27<sup>th</sup> January 2020

**Objection to application number 19/02700/F** - *Conversion of existing stone/brick barns to 1 no. dwelling and conversion of existing steel pole barn to 1 no. dwelling. Associated works including landscaping and new access at **Mawles Farm, Sibford Gower***

**Drawing title**  
Existing & Proposed Street Elevations  
Sheet 2 of 2

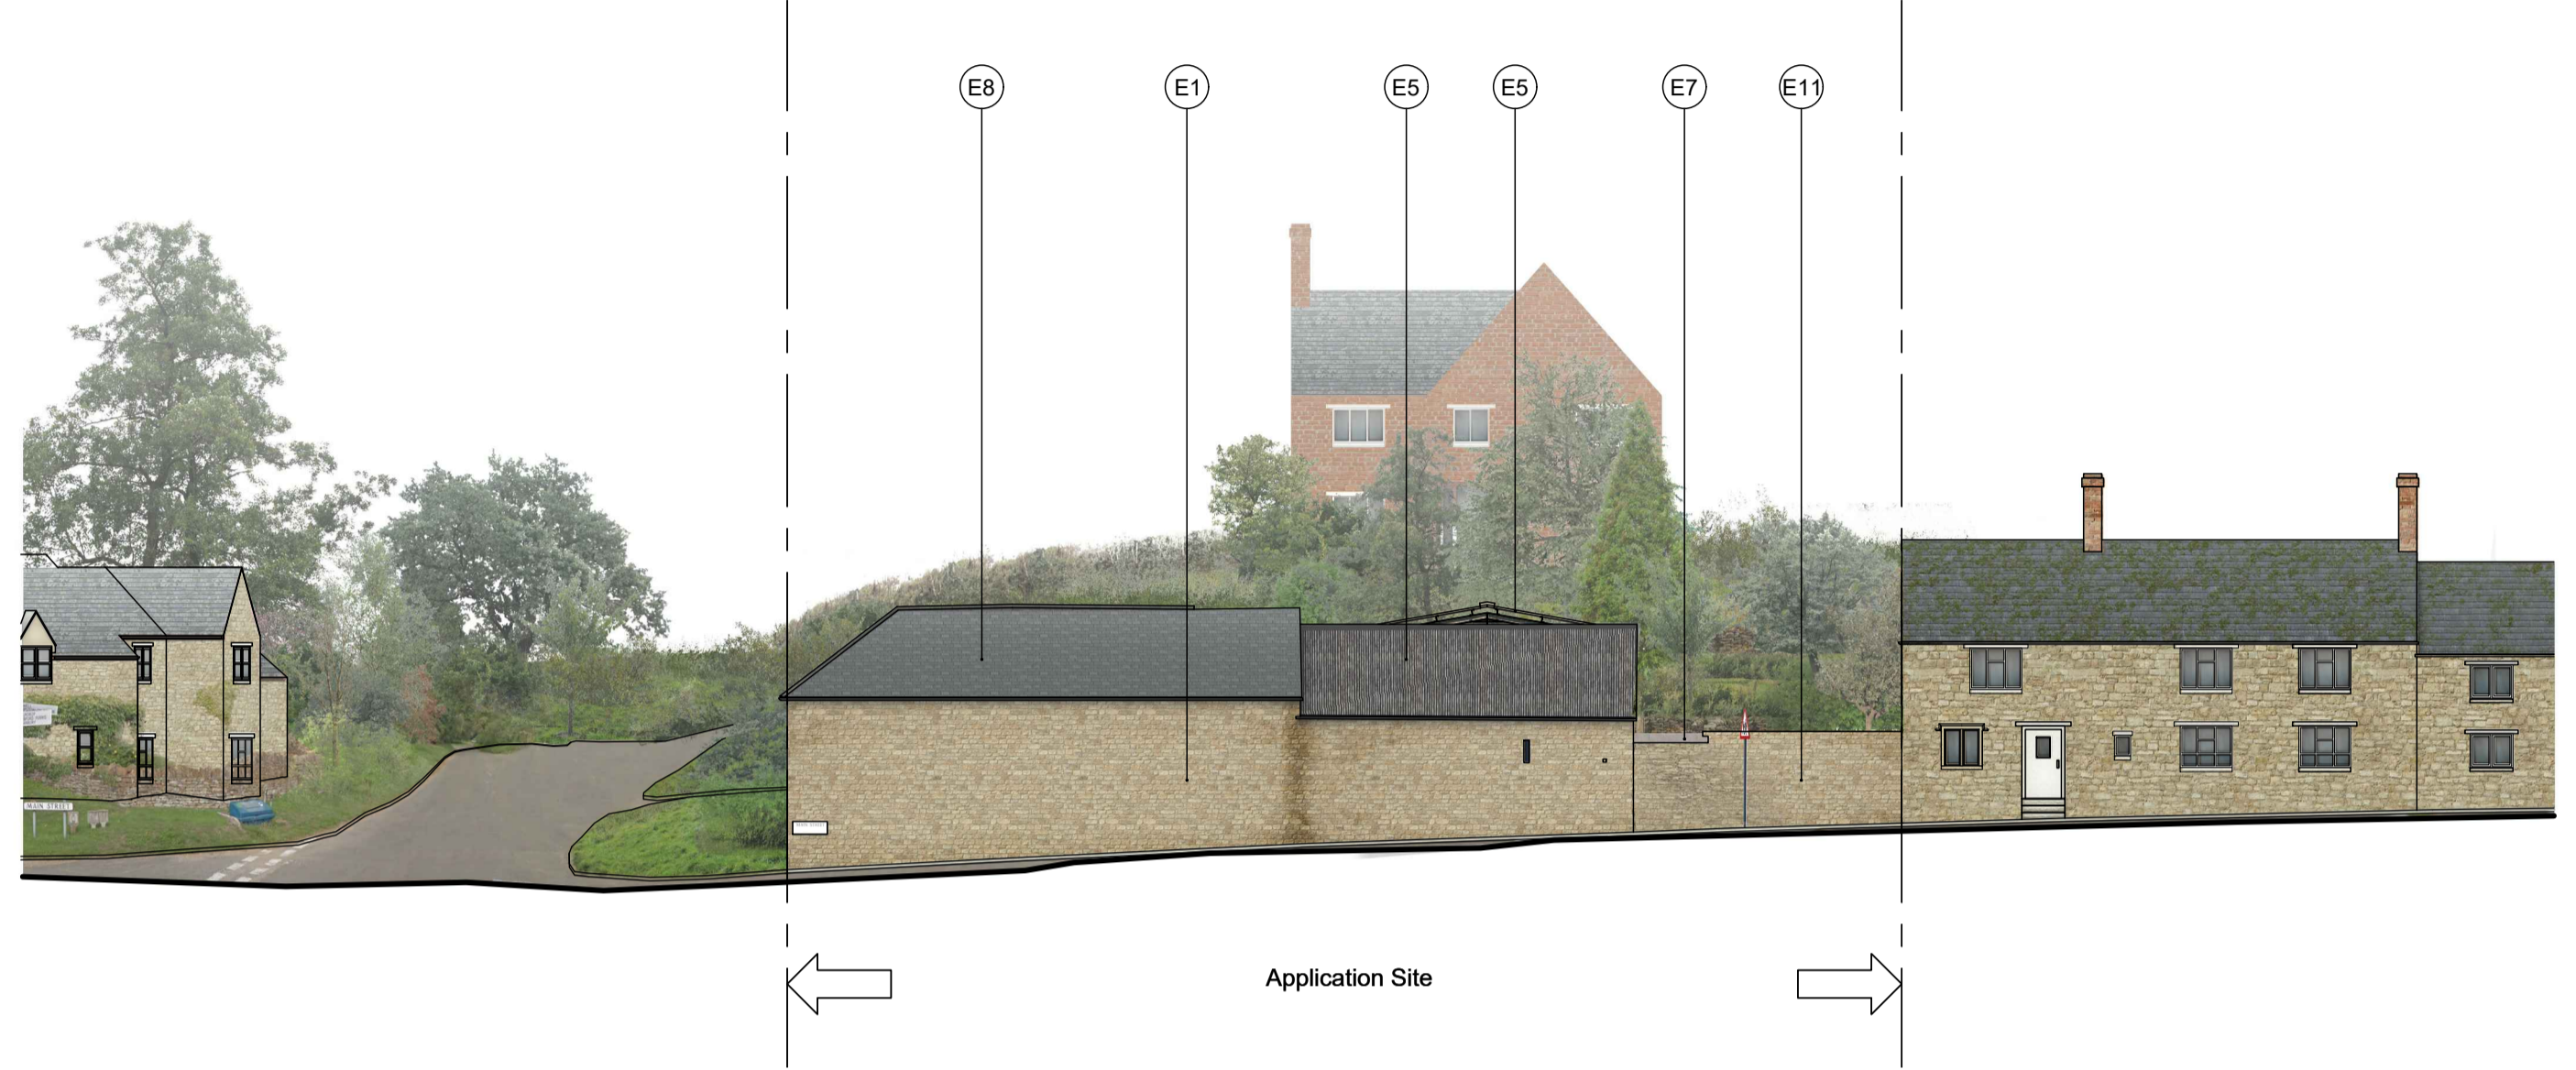
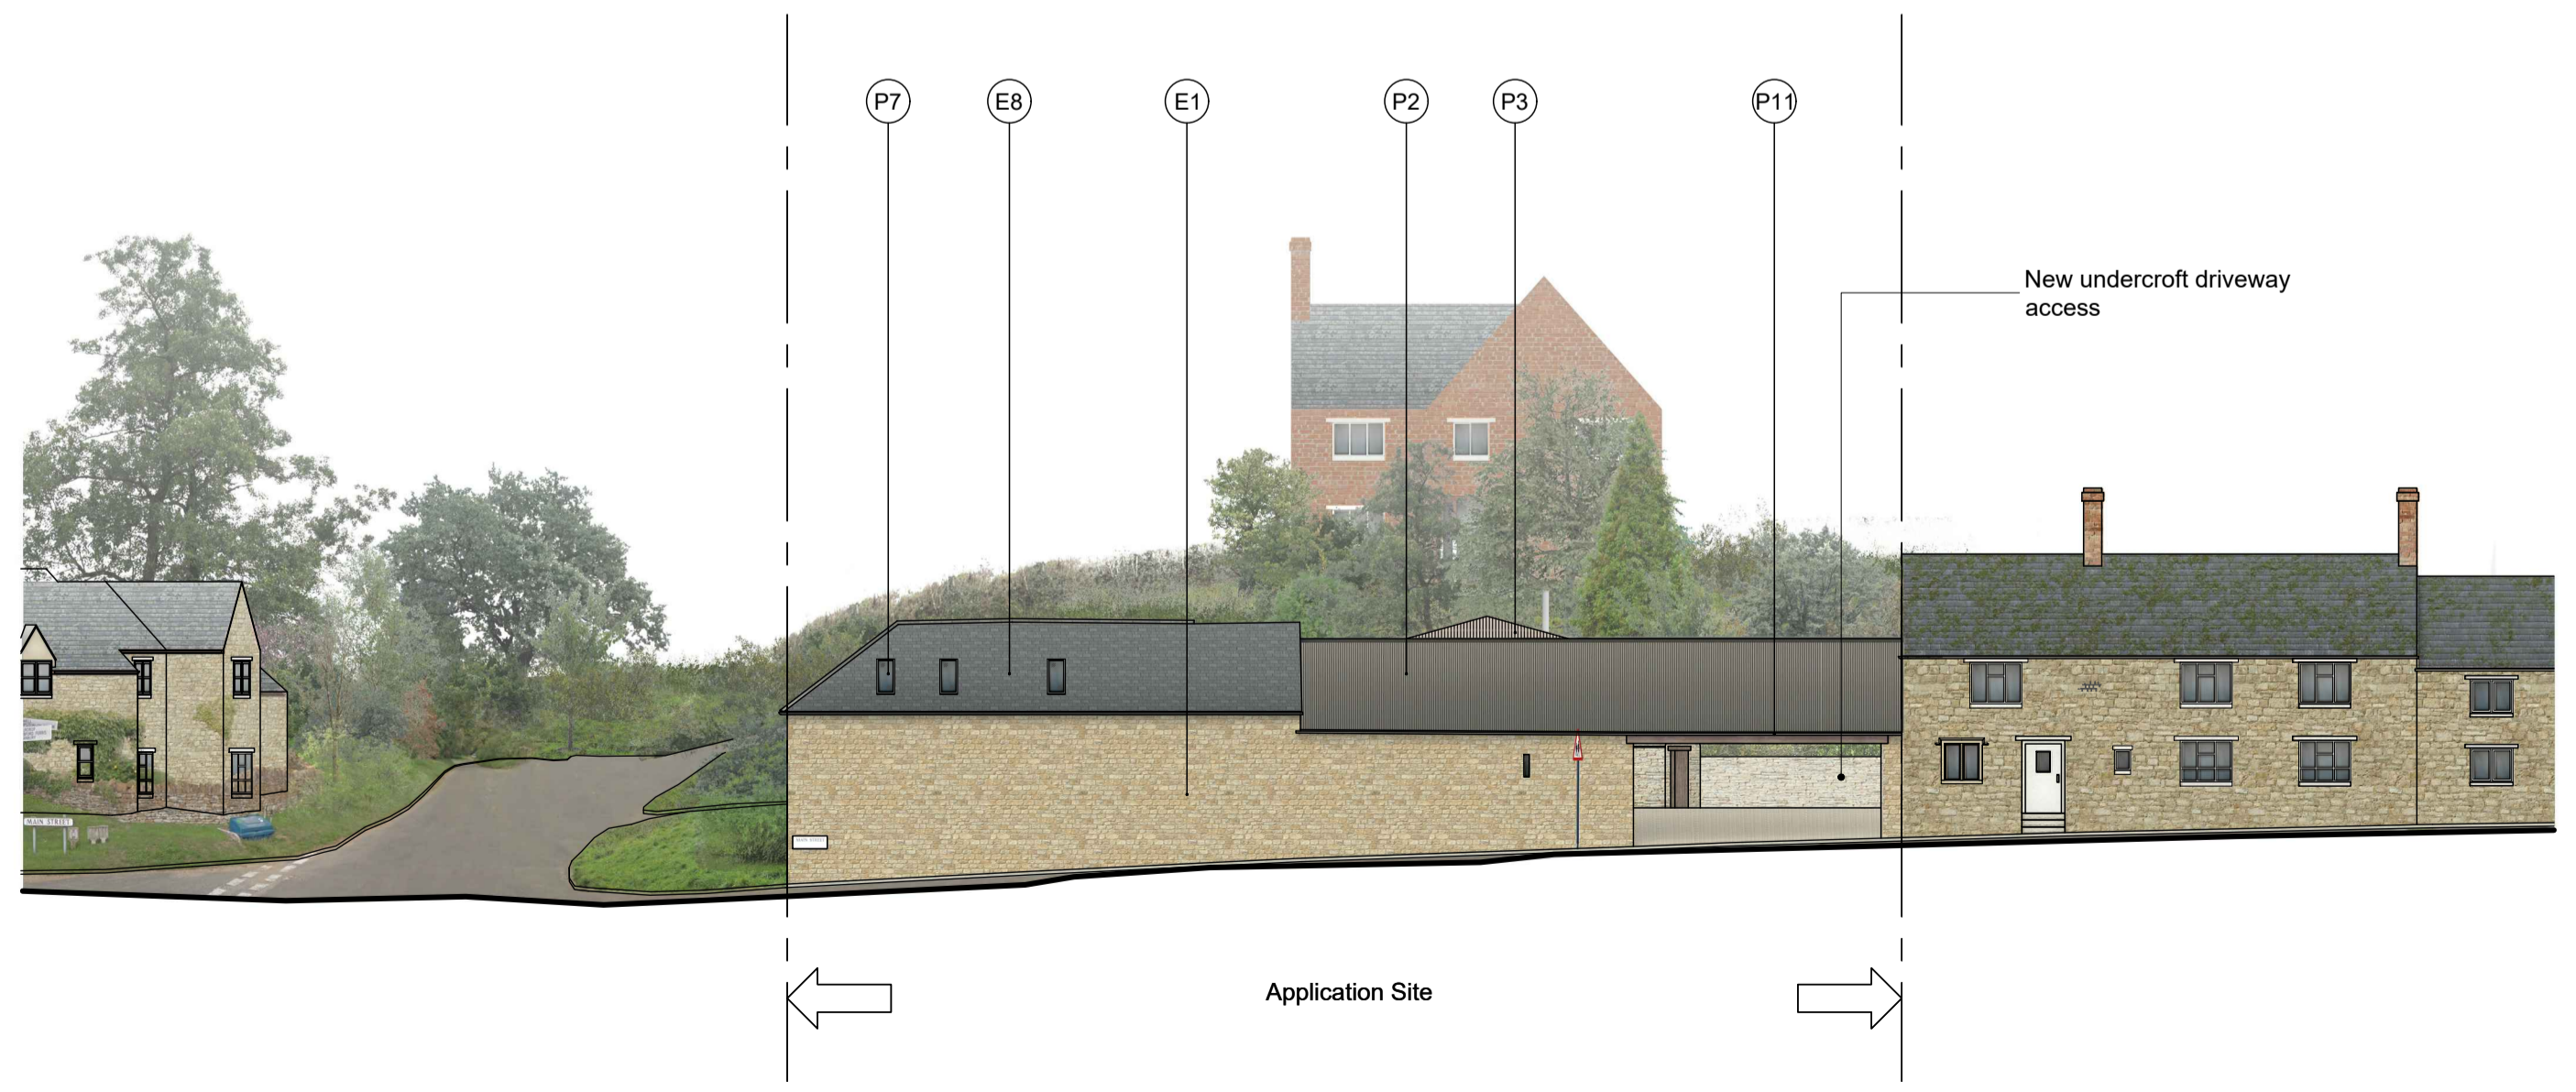
However, the main consideration and objection we have is the proposed access onto Main Street. This involves opening up an 8 metre wide gap on a wall that has been in place for over 100 years and possibly before that. The reason for opening up this gap would not seem to be of either planning or highways benefit, but ultimately to only serve to give more amenity and perhaps financial value to the traditional barn, which we understand will be sold away once planning is obtained. The applicants also own Mawles Cottage which is the principal dwelling connected with the farmyard and is currently being sold away from the farmstead. This large four bedroom property is not being sold with the benefit of its existing access from Pound Lane and will therefore only benefit from on street parking on the already congested Main Street.

Furthermore, with particular regard to the opening of the wall on main street, this is already causing serious safety concerns for both pedestrians and vehicles. This section of path is extremely well used by school children and their parents walking to and from the primary school twice a day, as well as people from the west of the village utilising the other services of the village such as the village hall, church, surgery and shop in Sibford Ferris. Young children seeking their independence will regularly run or scoot ahead of their parents and, with vehicles from a six bedroom property going in and out of this access on a regular basis, would be a serious safety matter and one which highways must carefully consider. However, this appears to have been given little consideration in the highways report already submitted by Oxfordshire

Equally, the difficulties of vehicles coming out of the proposed access and particularly going into this drive will be challenging when cars regularly park all the way down this side of the road. When parked cars are there, visibility of oncoming traffic will be virtually impossible. We note from the applicants submission that they say highways are supportive of this opening but have they fully considered utilising the yard area rather than on street parking and the impact of parked cars all the way along this road at certain points in the day? We also note that the access is one metre above the current road level so vehicles will be accelerating on exit and entry to take this into account, which gives added danger.
